Change of use from 1 no house into 1 no 1 bed flat, 1 no 2 bed flat and 1 studio flat.
Sandringham Wessex Avenue Bognor Regis

Thank you for your internet representation made on 13th July 2011 which has been recorded as **an objection** with the comments as follows:

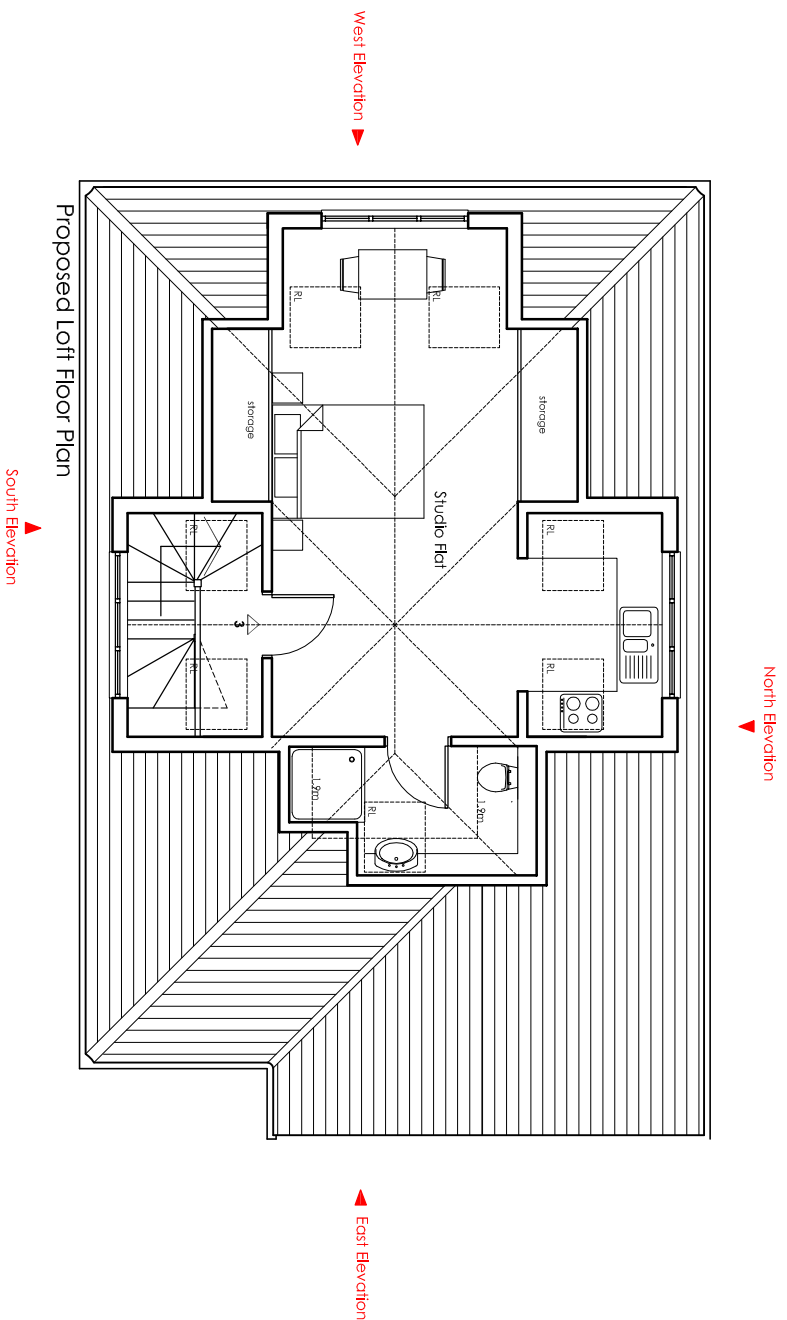
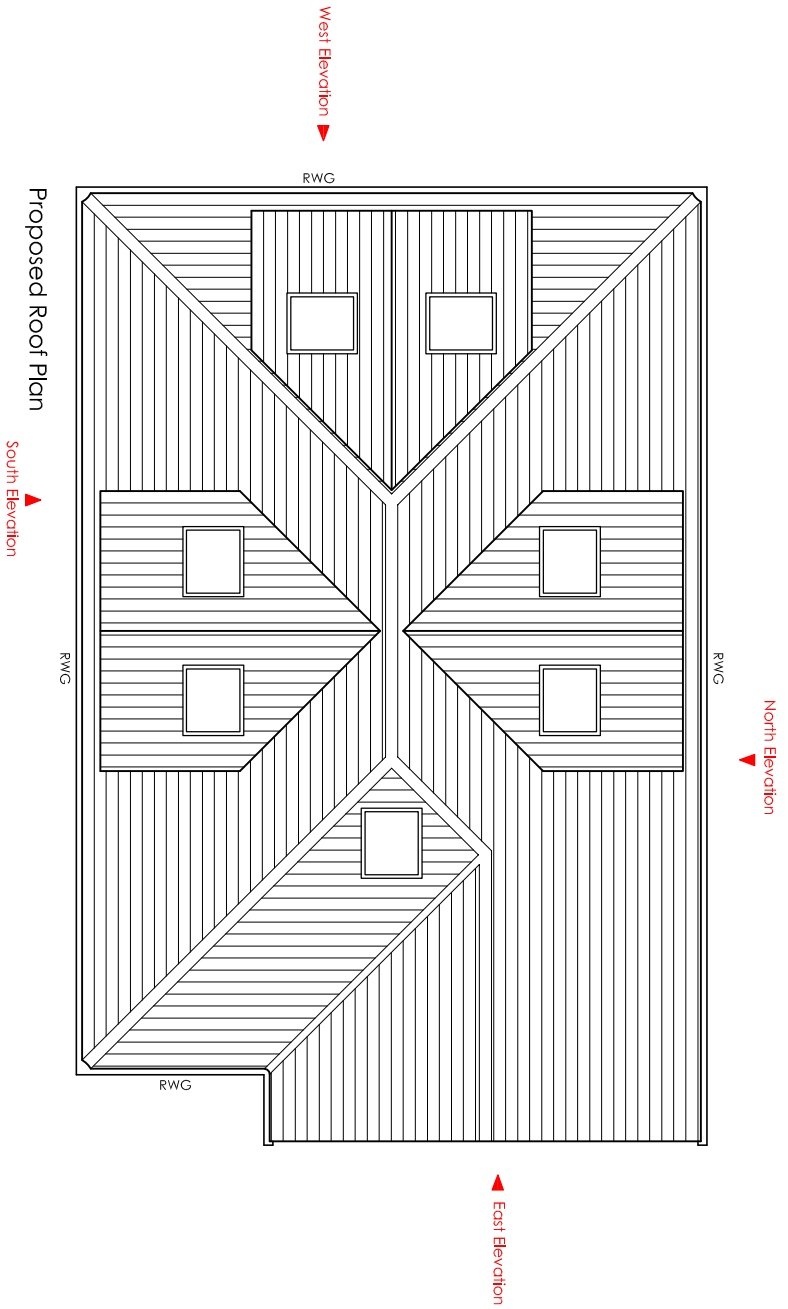
Having thoroughly looked at the proposed plans, I would like to start by saying that I have no objection to the development of the property into a ground and first floor flat, but do object to the proposed studio flat, which requires extensive overdevelopment of the roof. □

□
I object to this because of the excessive intrusiveness of the dormer windows to the neighbouring properties and more especially to us as an adjoining bungalow, which will have to take the brunt of the development in terms of a dormer and means of escape stairs, adjacent to our boundary. This is not acceptable and this development will intrude highly on privacy that already exists. □

Proposed Elevations

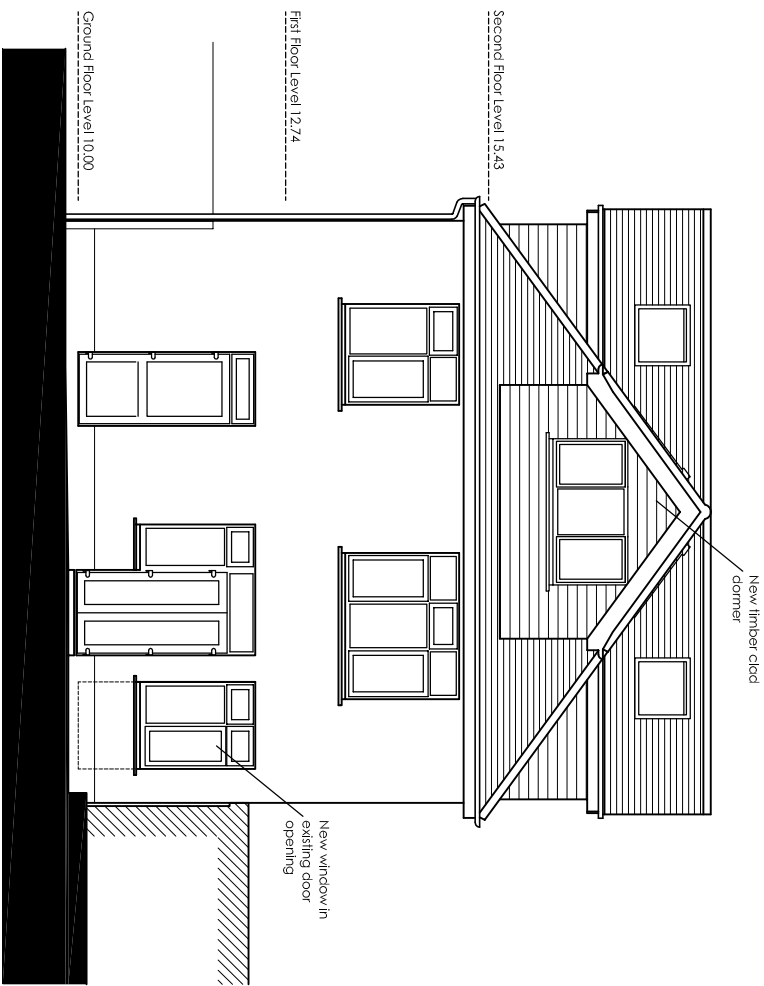
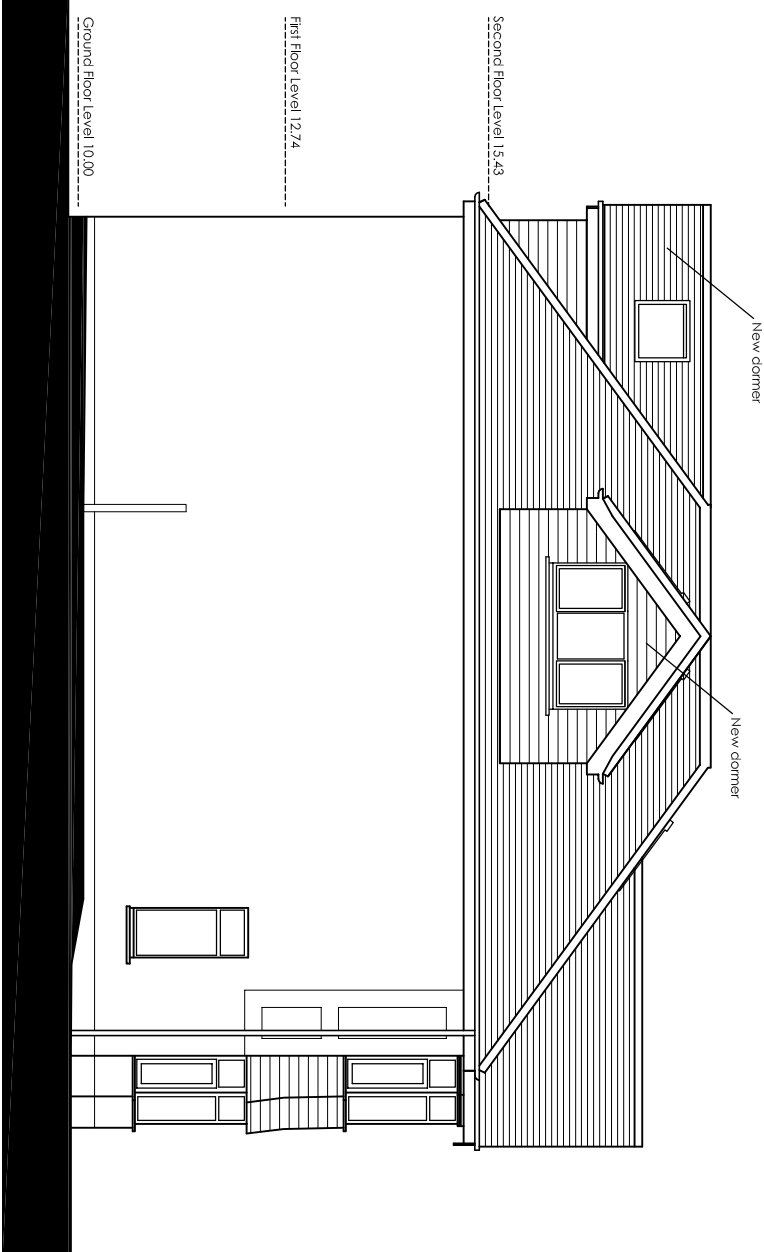
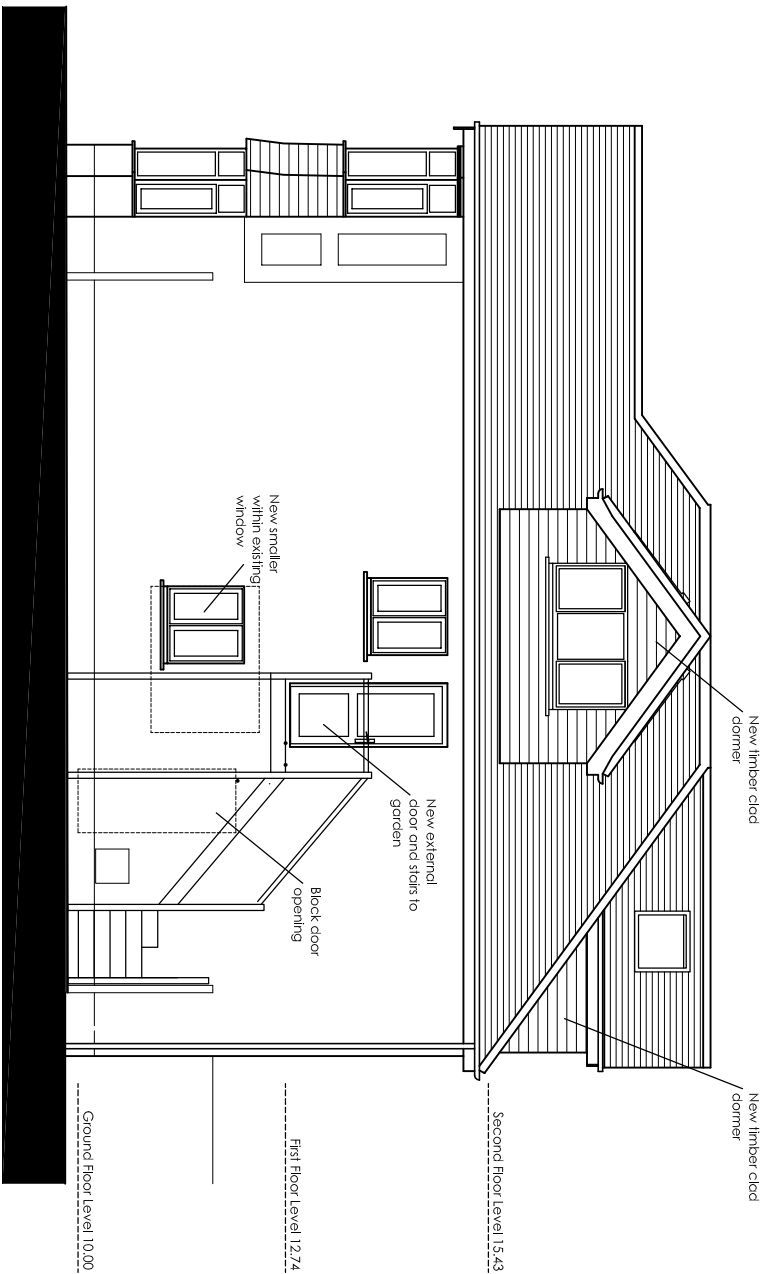
Further to my objection INET000011025, i would also like to add that the dormer development is not in keeping with the existing character of the road and i believe would impact upon the existing character of the street.
